Historic England

7 April 2020

**LAND ADJ TO PROMISED LAND FARM, WENDLEBURY ROAD, CHESTERTON,
OXFORDSHIRE
Application No. 19/01746/OUT**

Figure 8.6 – Alchester SAM

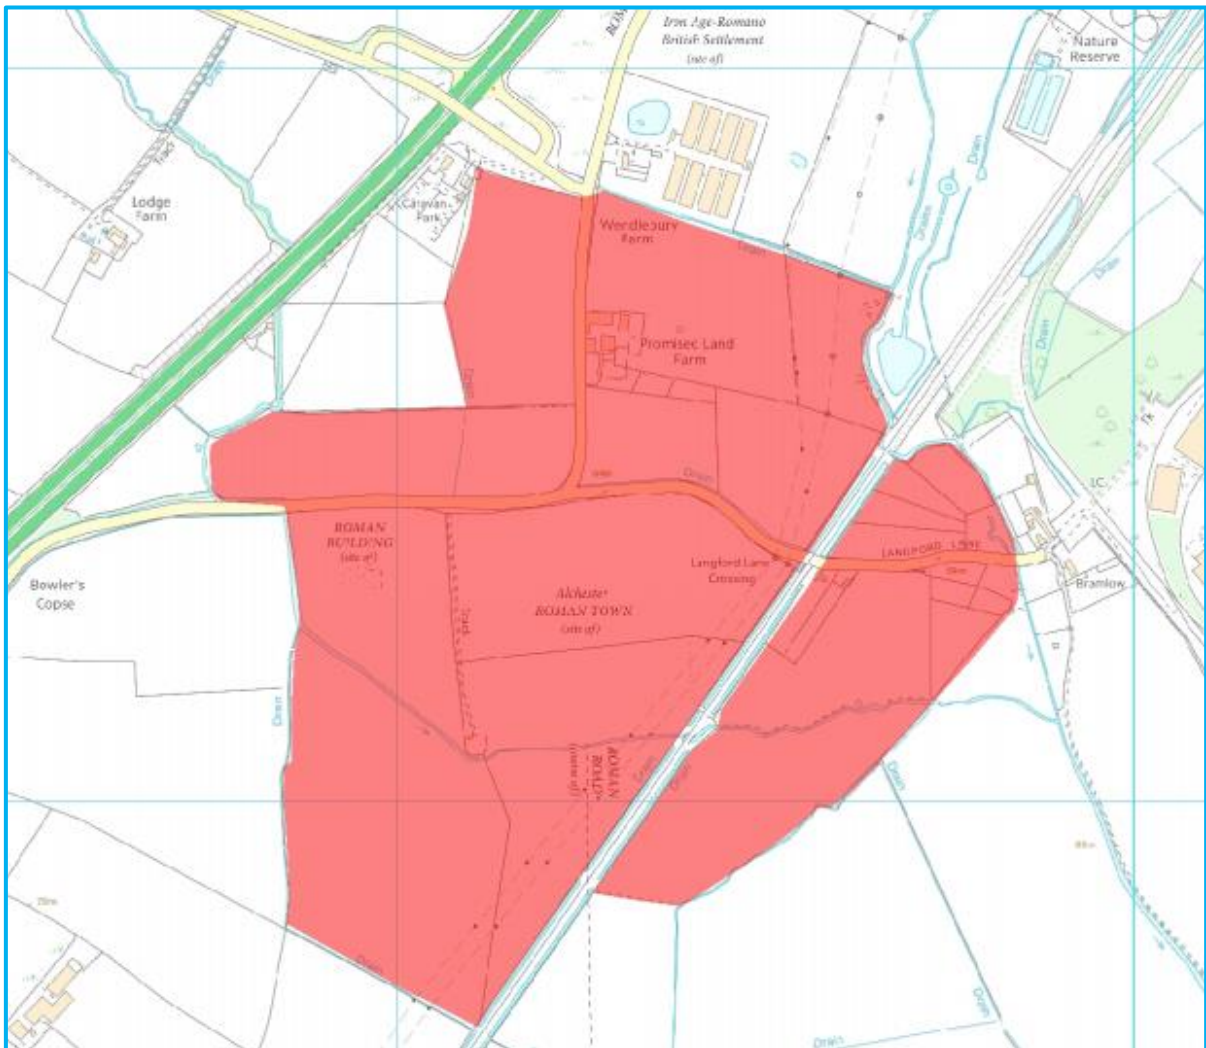
It is therefore not true either that the visibility of the new structures from the scheduled monument is irrelevant (DBA 5.26). The intrusion of modern built structures, 12 metres high, and set close to the scheduled monument boundary is a relevant consideration. This is why we previously advised that visualisations of the development as seen from the scheduled monument should be prepared. It is disappointing that this advice has been ignored.

Without the benefit of visualisations, but using my own knowledge of the scheduled monument, I advise that the new buildings will bring urban-type fabric closer to the scheduled monument, adding to the modern structures which already exist, such as the railway line. The buildings are longer and higher than the existing chicken farm structures. For visitors experiencing an abandoned Roman town, consisting of agricultural fields, the modern structures will detract from the experience and are therefore harmful. This harm will be less than substantial. There is no formal scale of less than substantial harm but in this case the harm would undoubtedly be at the minor end of the spectrum. NPPF paragraph 196 requires that less than substantial harm should be balanced against public benefit, in determining the planning application.
